R/285/19/HH - 17 Glenville Road Rustington (single storey rear extension)

With regard to the above project my client (in the spirit of being neighbourly) has instructed me to reduce the bulk of the extension located within the outrigger as indicated on the revised drawings 1934-03D and 1934-04D enclosed.

PLANNING ONLY

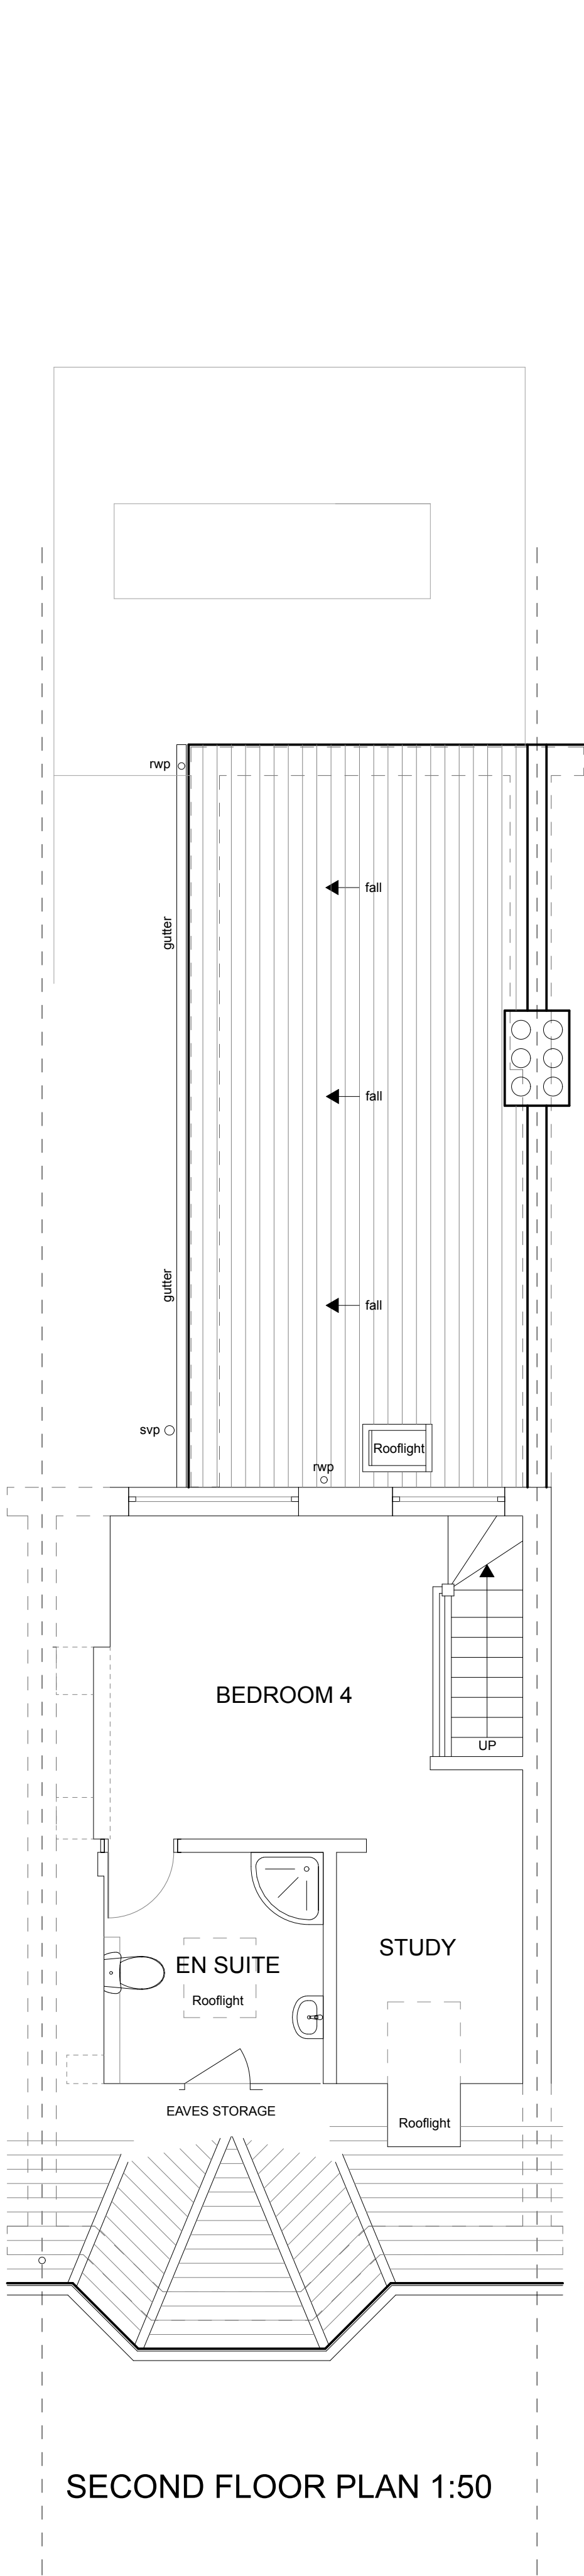
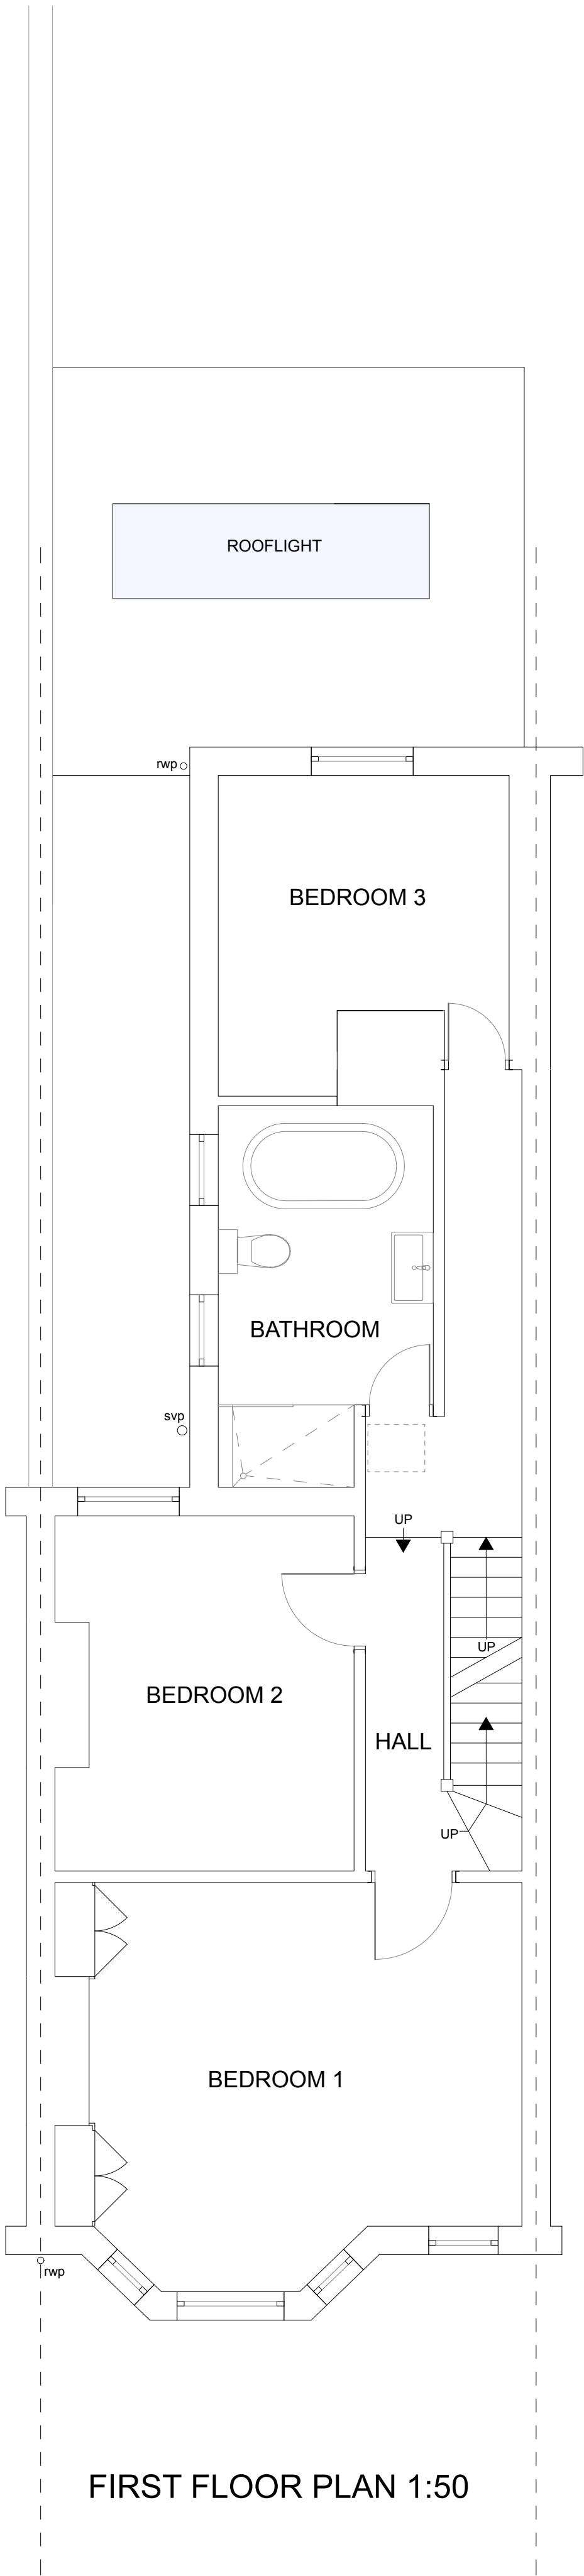
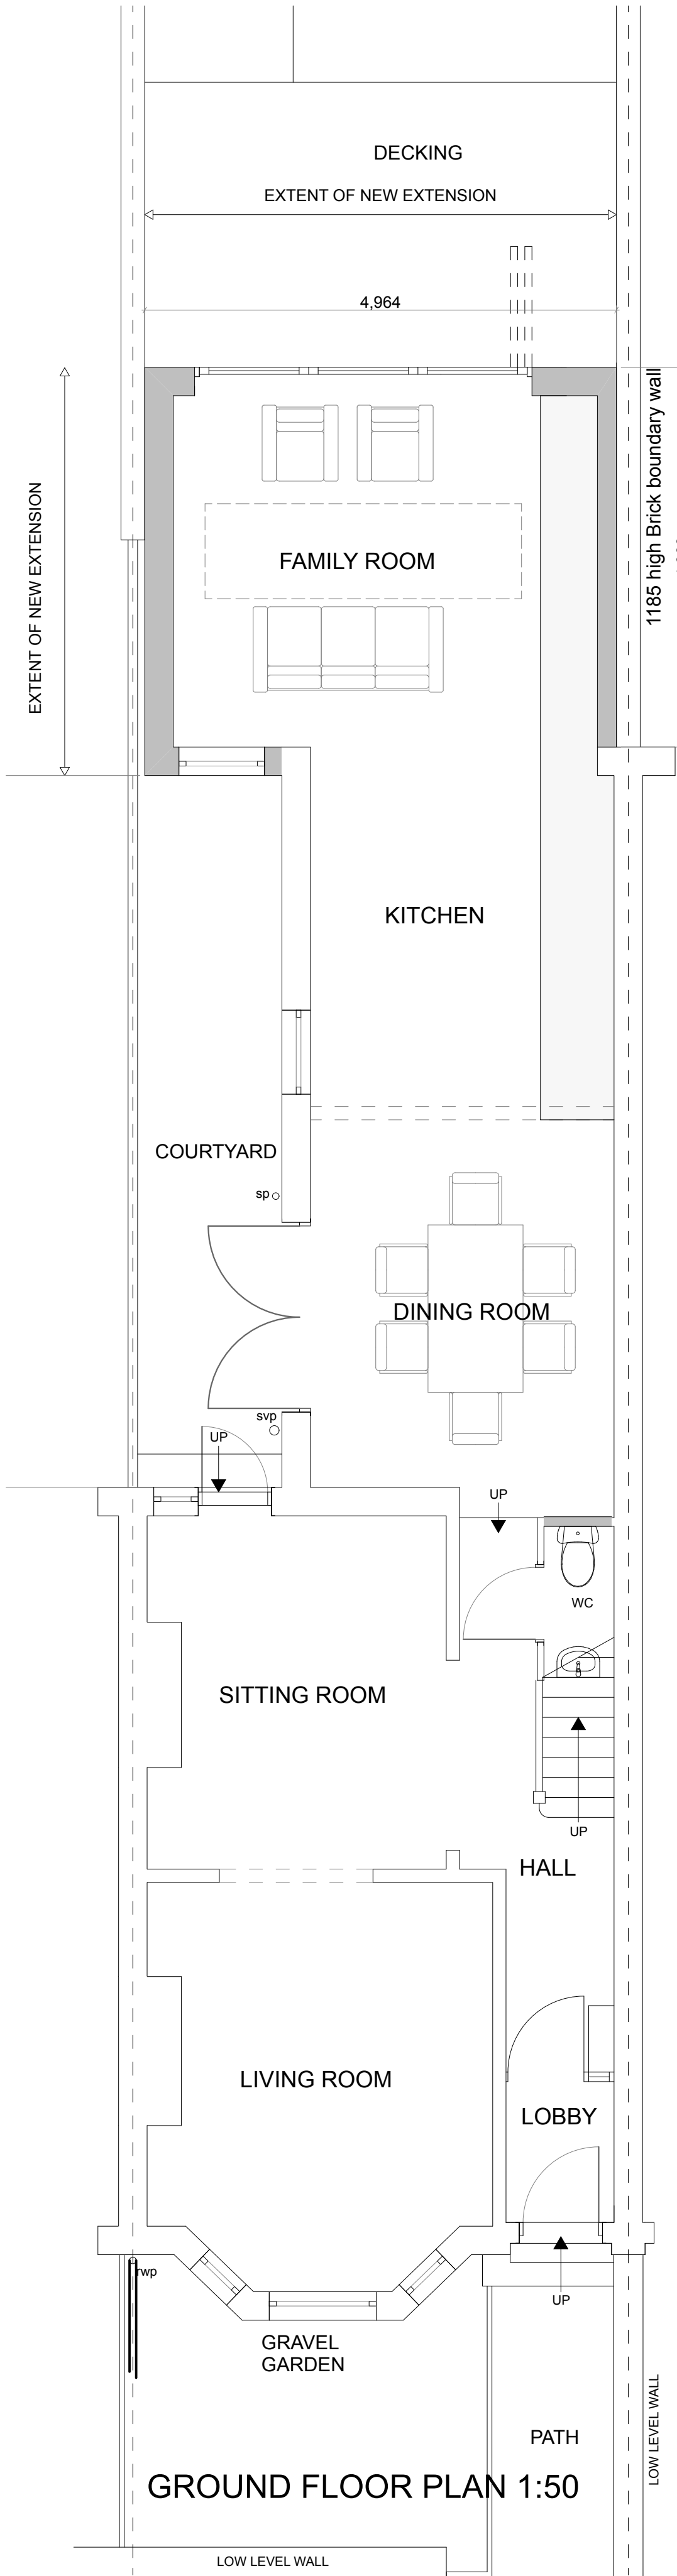
Whilst they have no objections to the main part it is the return down the side that was concerning them.

Light is a major issue as these North rooms are dark and their large side window would effectively be looking at a solid wall. I fully appreciated their concerns - I would have had the same, roles reversed.

I like our neighbours and do not wish to upset the apple cart for a few extra feet. Is it possible to amend the plans so that the extension purely covers the back of the house and not down the side return?

The side door in the kitchen (leading out to the Courtyard) will remain blocked up as on the plans but both of the single windows will be re instated. Finally, could we have a fully glazed window/ door looking into/ down the Courtyard from the new extension.

Happy new year and thank you for your e mail.
I have now amended the drawing which you may wish to further discuss with your neighbour.
I've adjusted the rooflight position to suit the revised shape of the room.
I would be tempted to introduce a window to the courtyard elevation within the existing door location.
